# CITY OF PORTLAND, MAINE

March 14, 2016

Project Name: **Murrell/Howe Duplex** Project ID: 2015-02404  
Address: 40 Quebec Street CBL: 014 H 003001  
Applicant: Matthew Murrell & Katherine Howe  
Planner: Philip DiPierro

1 Site Plan
3/16" = 1'-0"

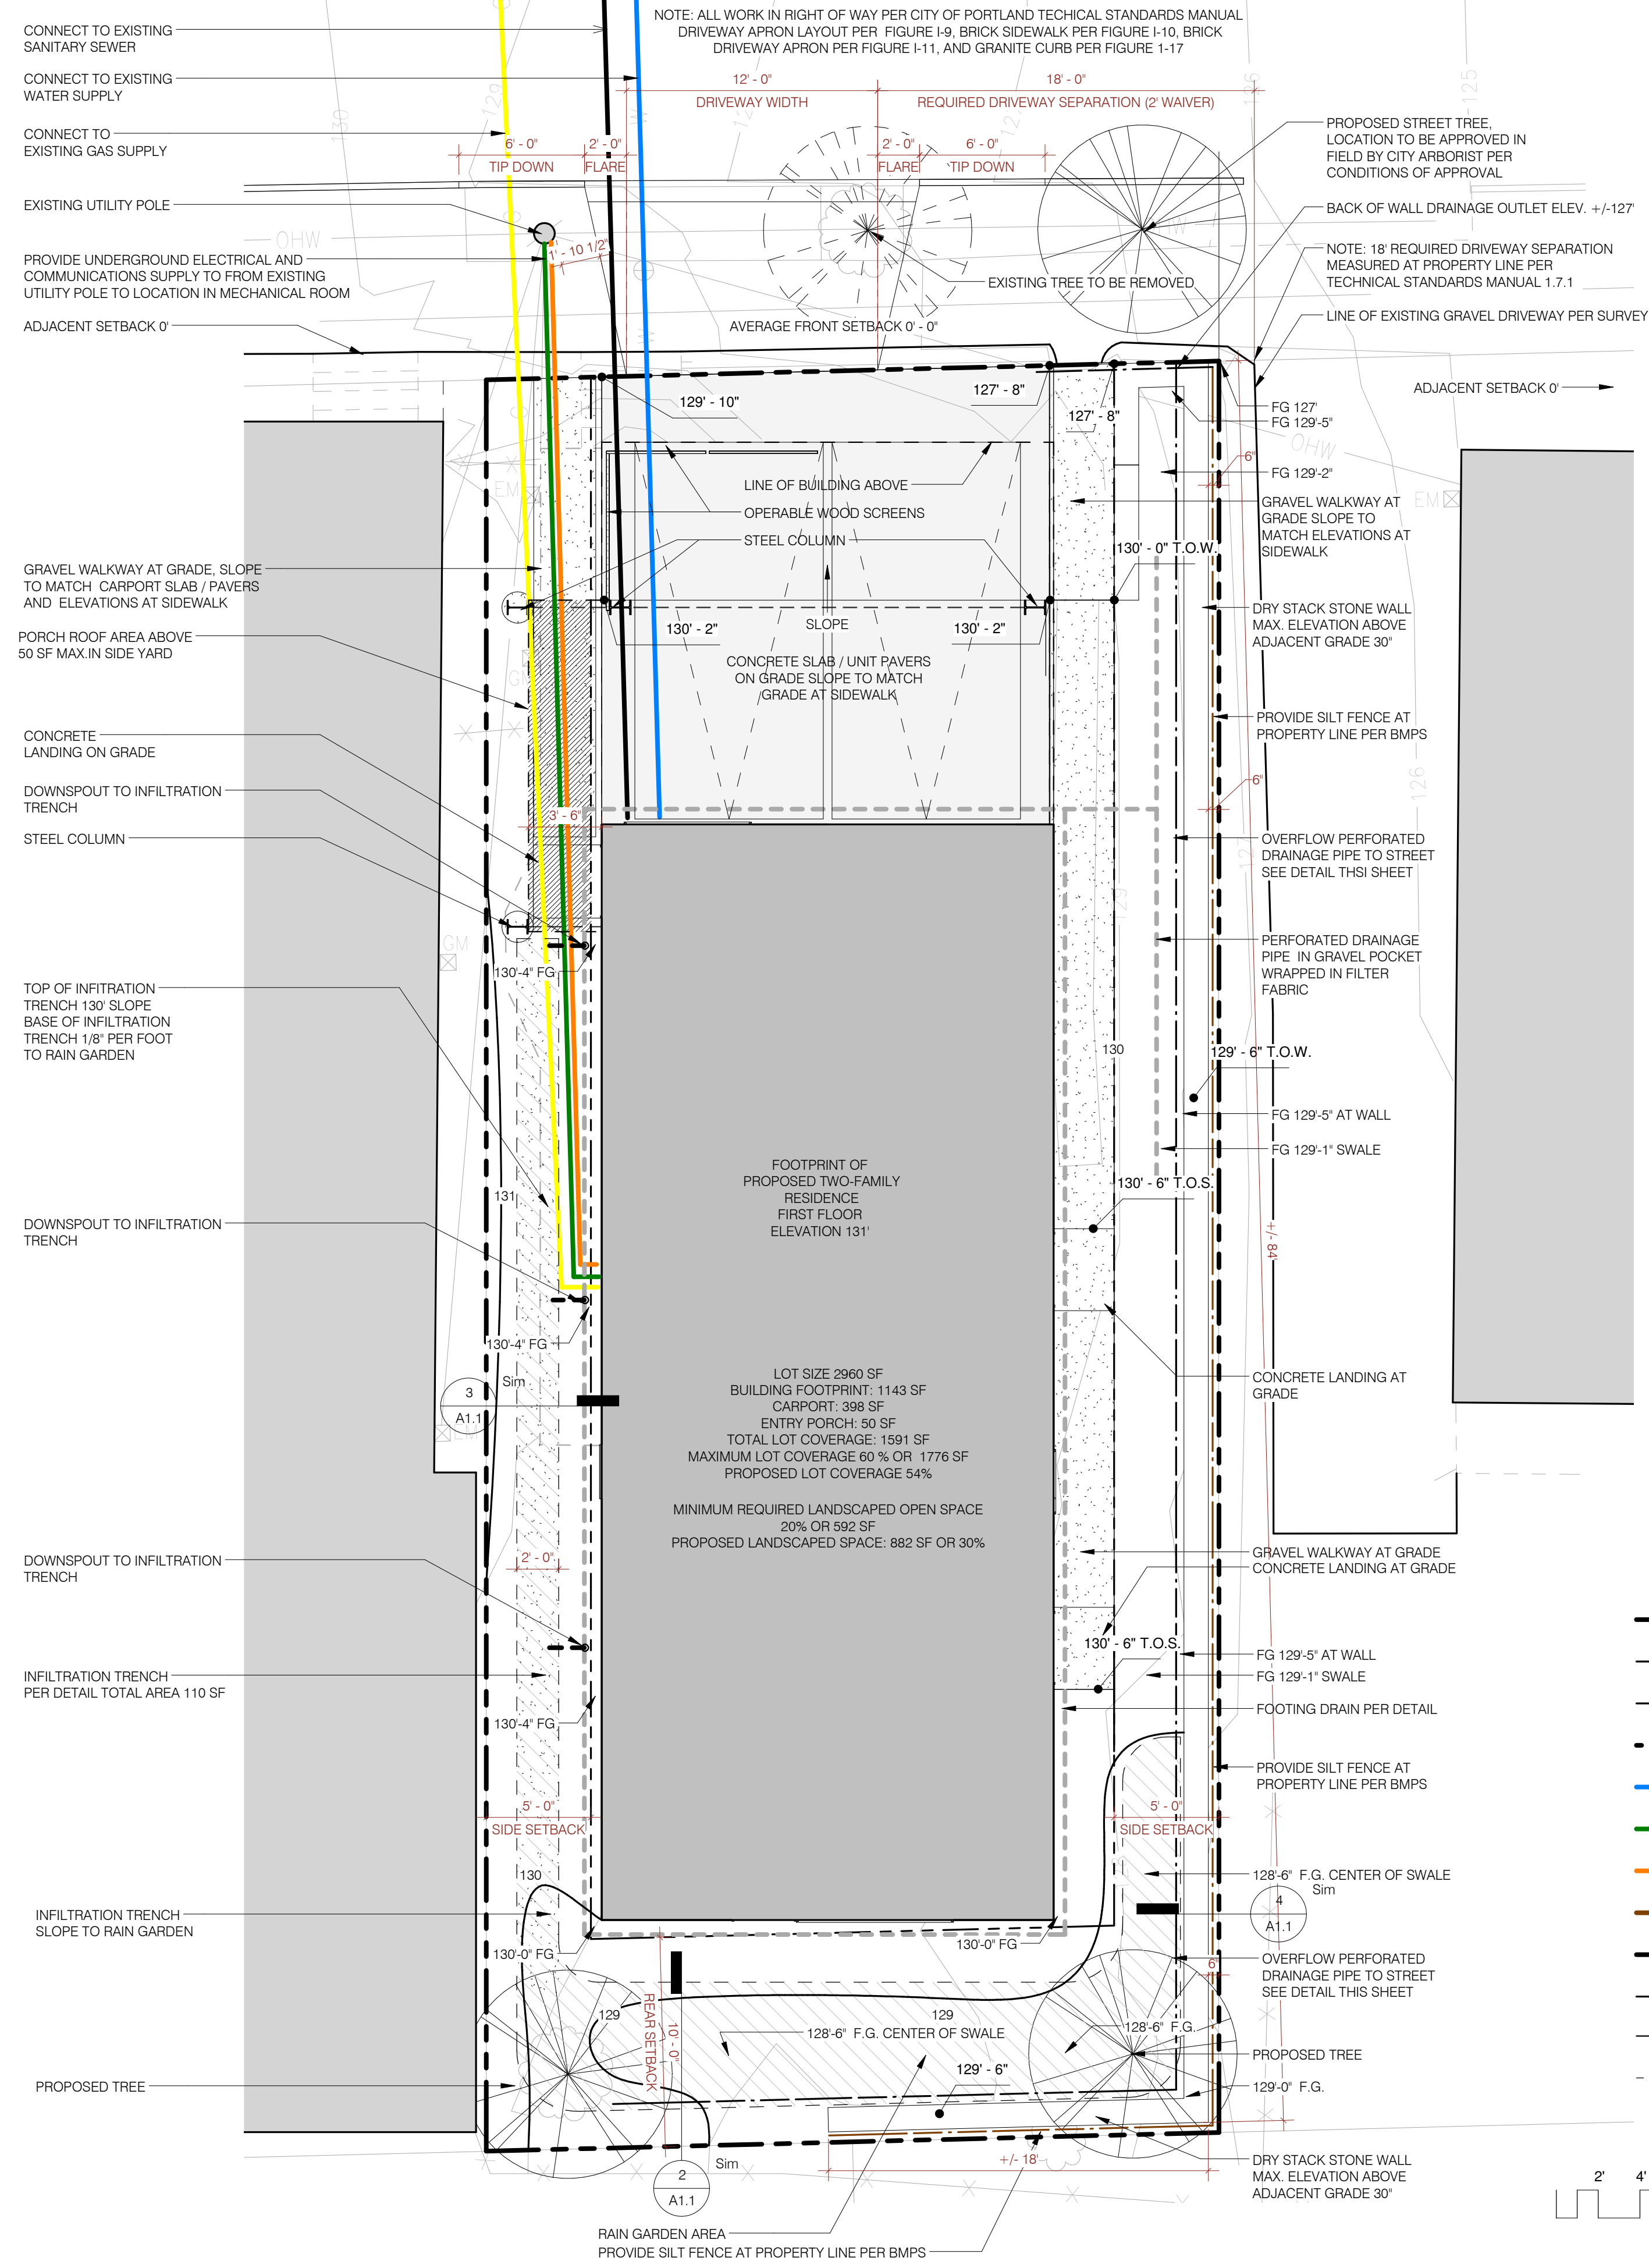
1. The Planning Bound finds that extraordinary conditions exist and that undue hardship results from strict compliance with Standard Section 1.7.1. of the City of Portland's Technical Manual that requires "...a minimum distance of twenty (20) ft. spacing between adjacent driveways" measured at the property line, and has varied the regulations, so that substantial justice may be done and the public interest secured; therefore, the Board waives two feet of the 20 foot driveway separation standard to allow for an 18 foot separation, as recommended by David Margolis-Pineo, Deputy City Engineer of the Department of Public Works. As a condition of the waiver approval, the applicant must submit a revised site plan that meets the driveway separation requirements stated by Deputy City Engineer, David Margolis-Pineo.

1. Prior to the issuance of the building permit the applicant shall revise the site plan so that it meets the partial waiver criteria outlined above for the curb cut and driveway spacing as follows; - the applicant is to close the proposed driveway cut width to 12 feet, increasing the separation distance between driveways to 18 feet, as measured at the property line.
2. Prior to planting the street trees, the applicant shall meet with the city arborist to field locate the proposed street trees,
